Vacation of 20' Utility Easement  
24830 Impala Circle  
Lot 29,  
Antelope Acres No. 2  
Section 29, Township 14 South,  
Range 62 West of the 6th P.M.,  
El Paso County, Colorado

# Markup Summary

**"Exhibit A"**  
**Vacation of 20' Utility Easement**  
**24830 Impala Circle**  
**Lot 29,**  
**Antelope Acres No. 2**  
**Section 29, Township 14 South,**  
**Range 62 West of the 6th P.M.,**  
**El Paso County, Colorado**

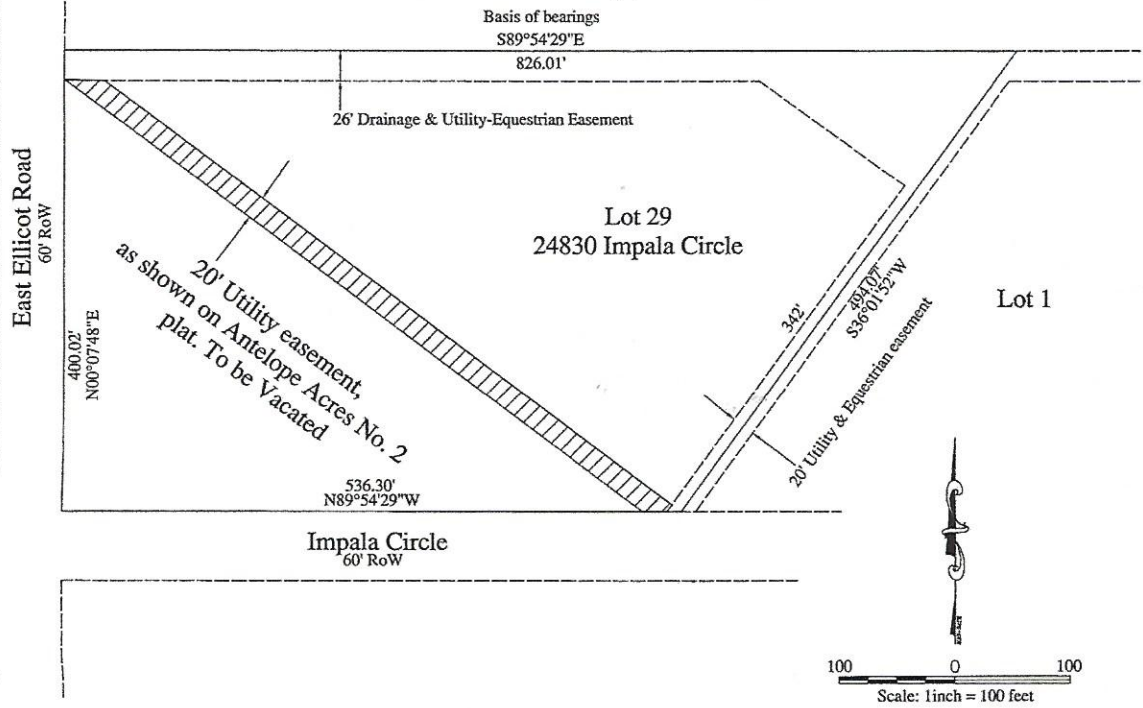
Write "Exhibit A"

I thought this was a well water easement?

Show the other easements as continuing, and hatch the easement that is being vacated.
